April 8, 2016

RE: 749 CONGRESS STREET

In response to Staff comments, we have made the following changes:

**GRADING & UTILITIES PLAN**

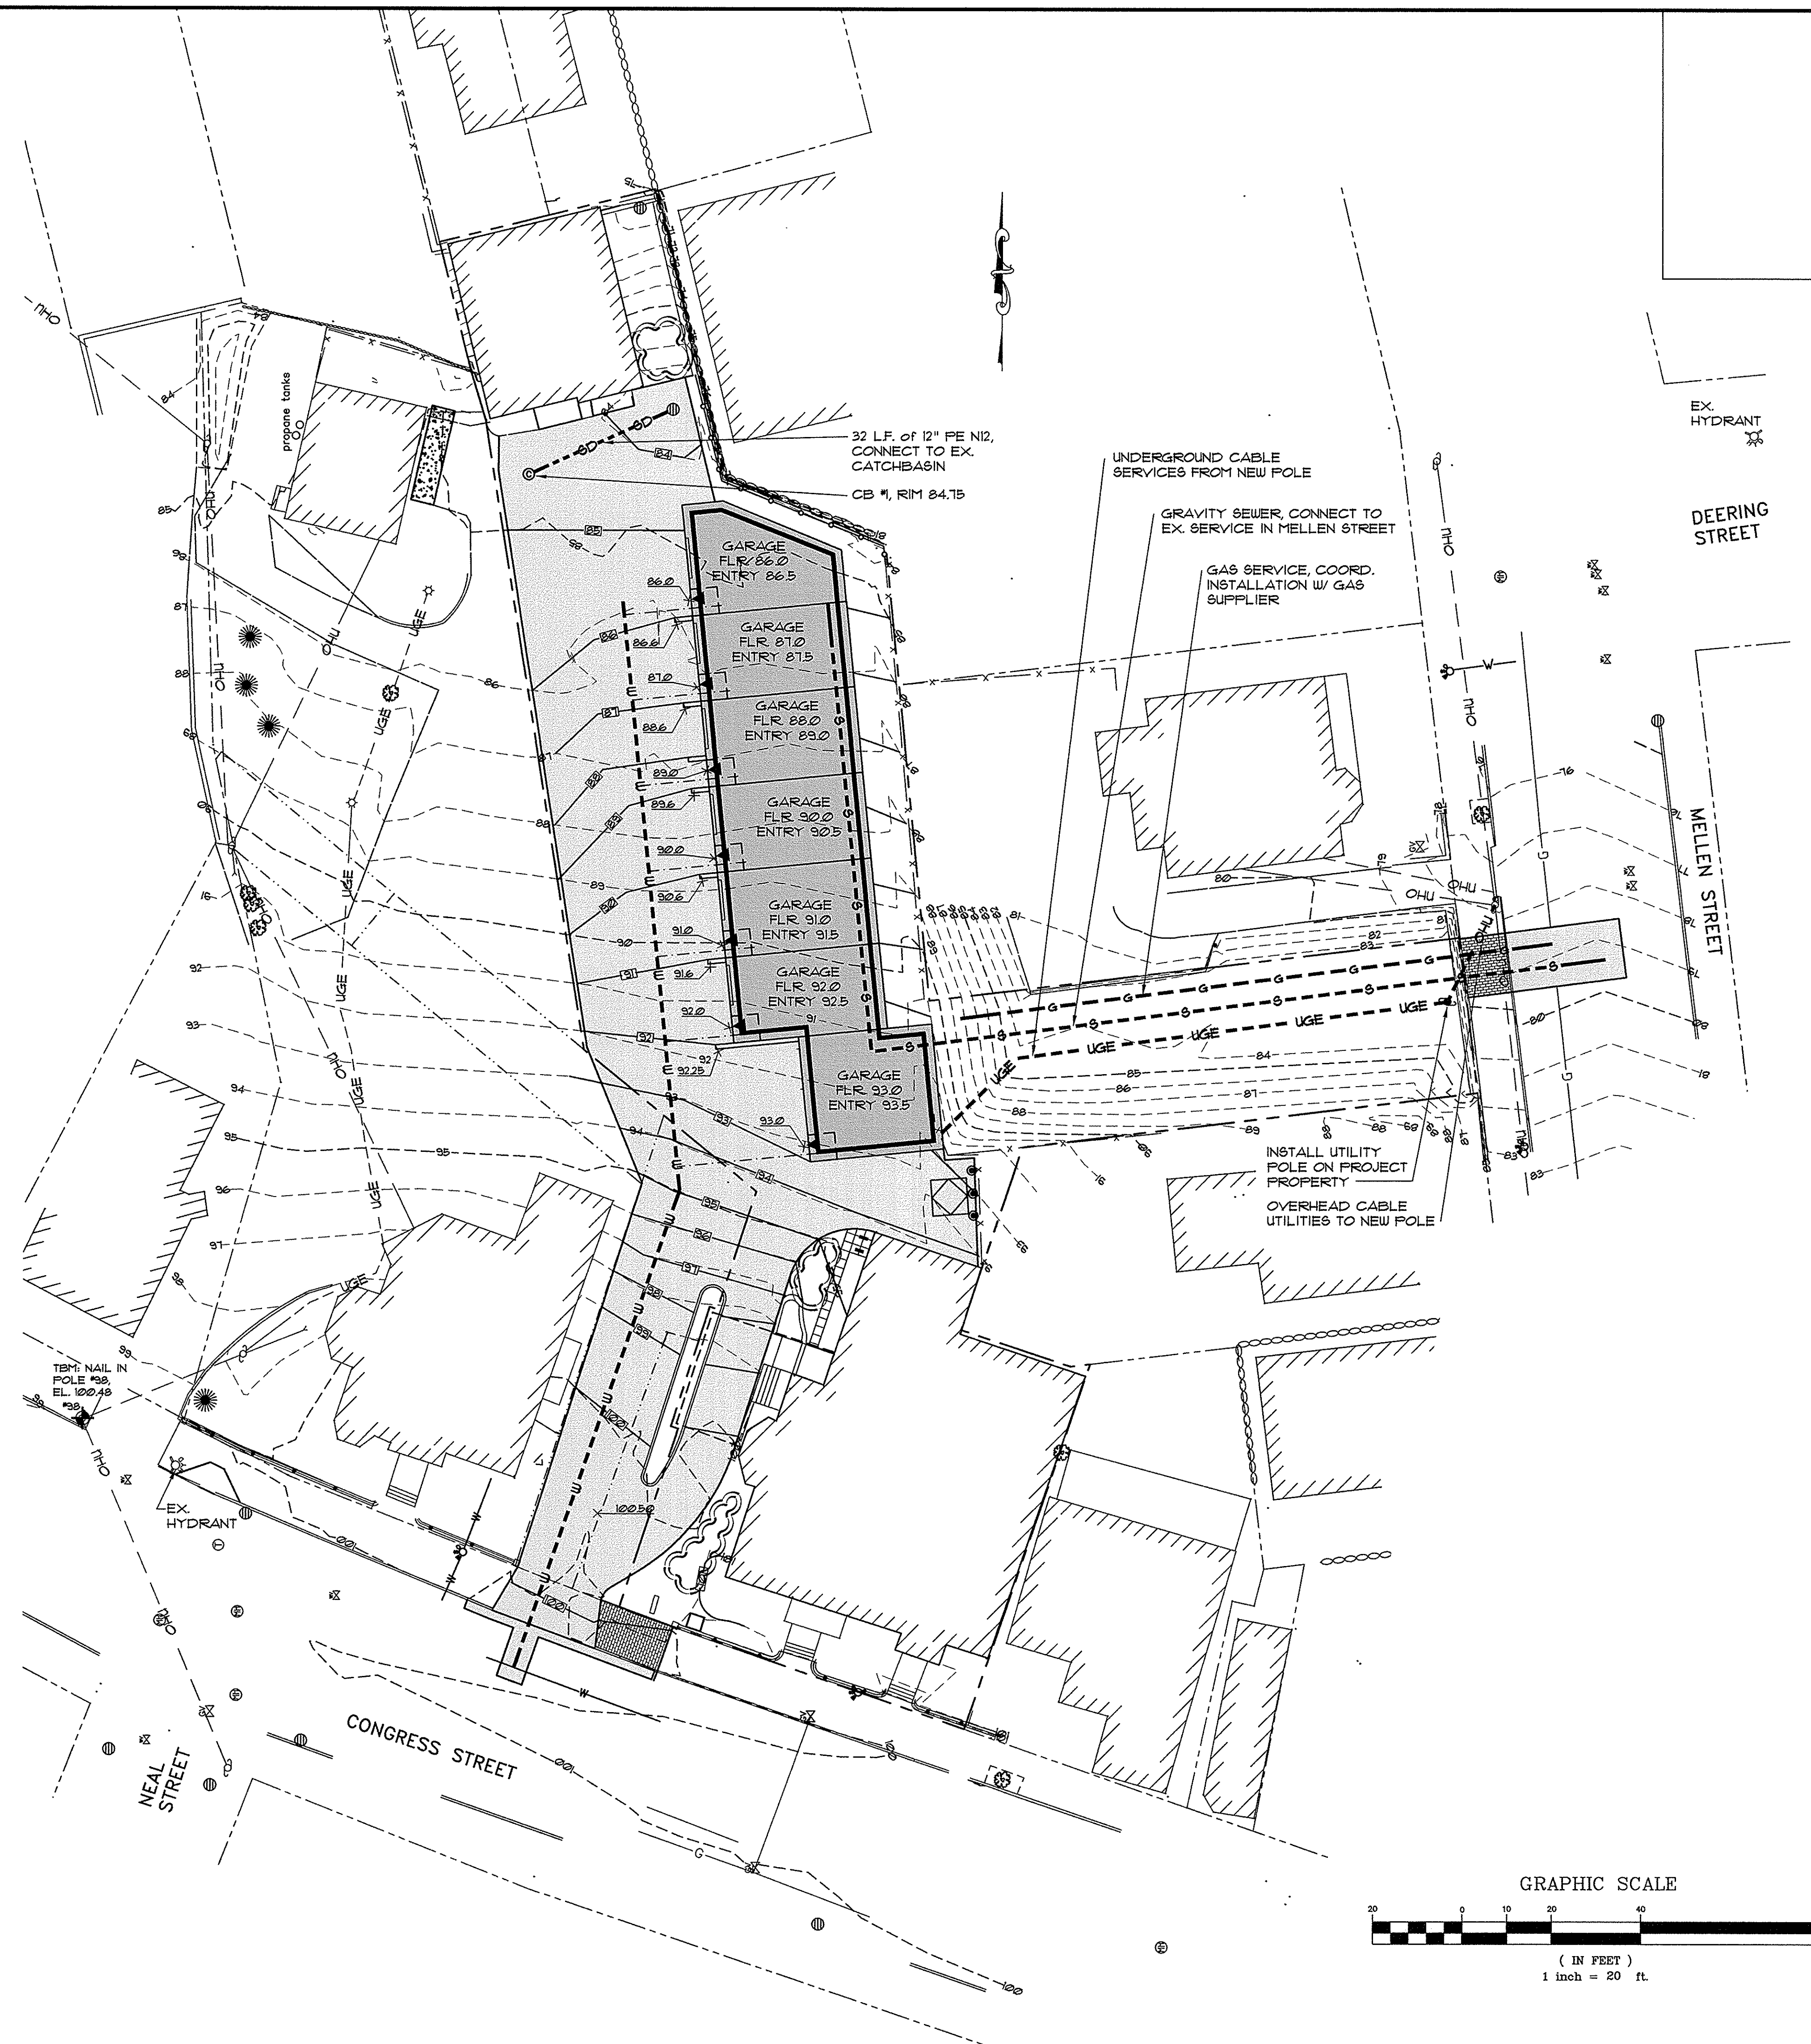
4. We have added a 4' high fence around the Mellen Street connection.
5. We will be reconstructing the retaining wall on Mellen Street.
6. The water lines have been revised to provide separate services to each lot.

12. We now show where the 8" clay pipe goes on the plan. We cleaned the catch basin and TVed the line. The pipe is in excellent shape. It goes 106 feet down the hill to a 90 degree main. This is under the building on Cumberland Avenue.

13. We added a foundation drain connection and drip strip connect to a new catch basin, replacing the existing brick catch basin. The basin will have a 3 foot deep sump.

EROSION CONTROL PLAN, NOTES AND DETAILS

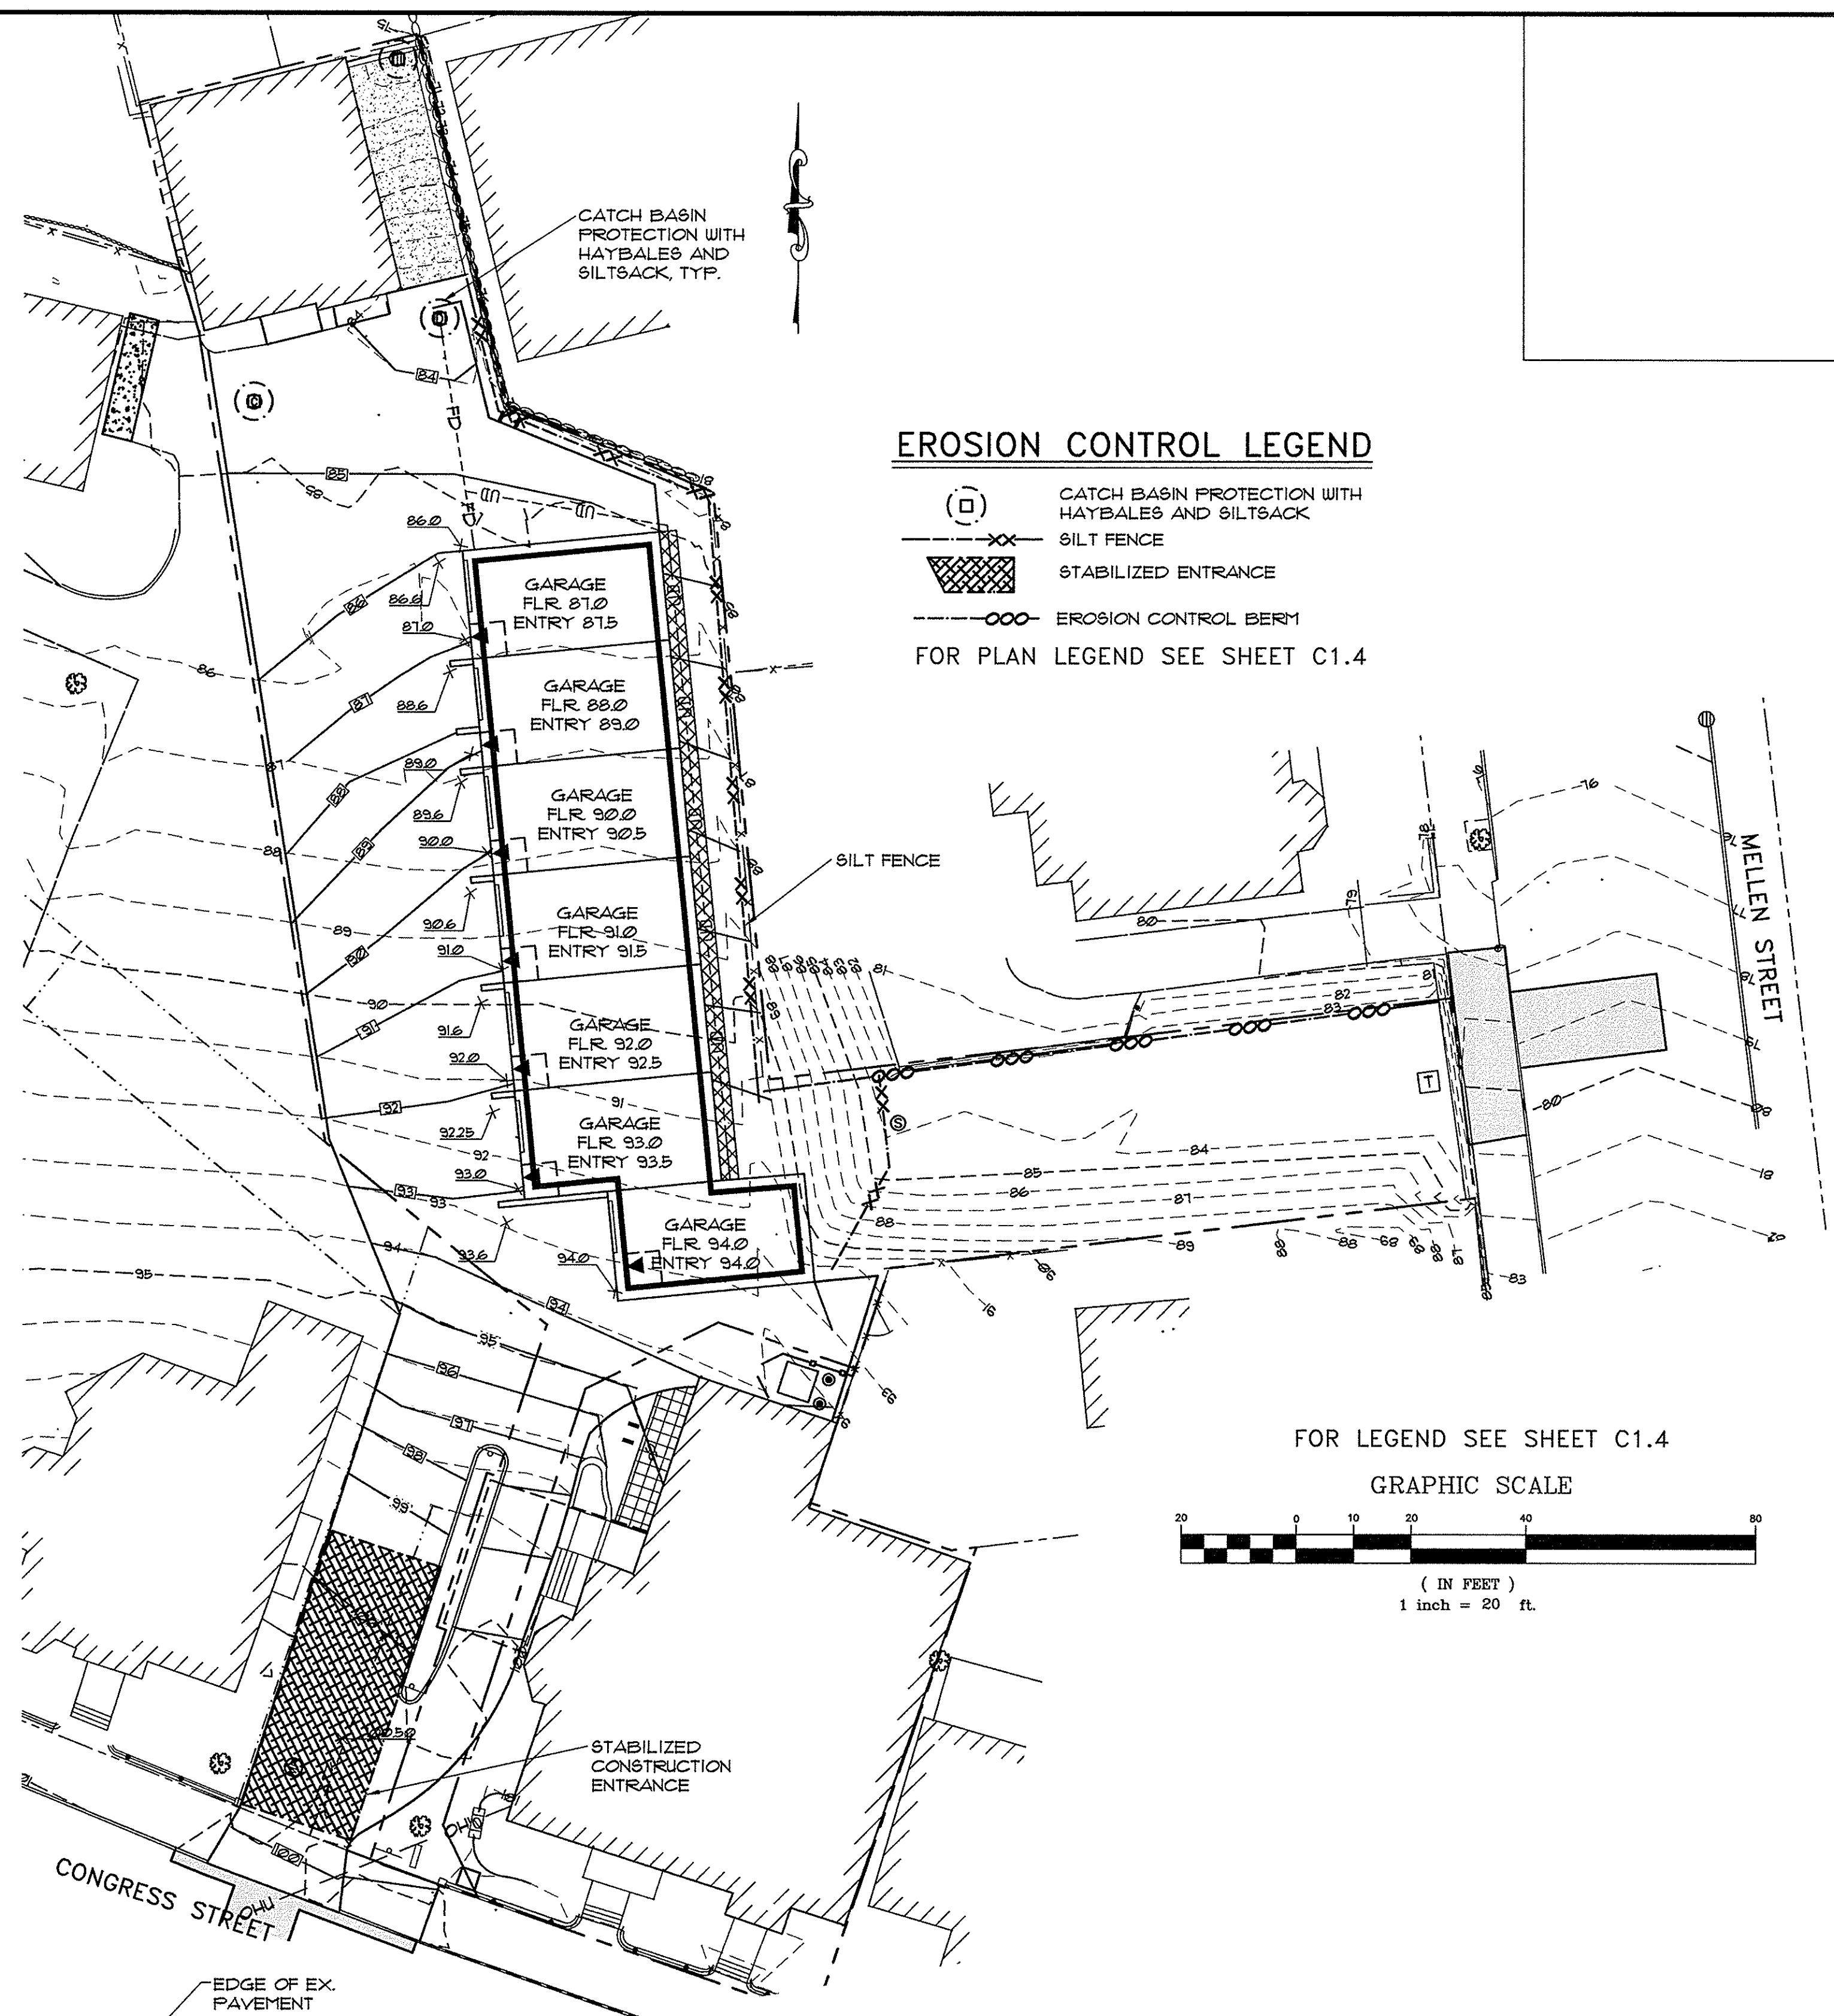
17. Attached are cut sheets for the lighting fixtures and a photometric plan.
18. We have revised the shading so the survey data shows.
19. We have added erosion control berm to the Mellen Street connection.
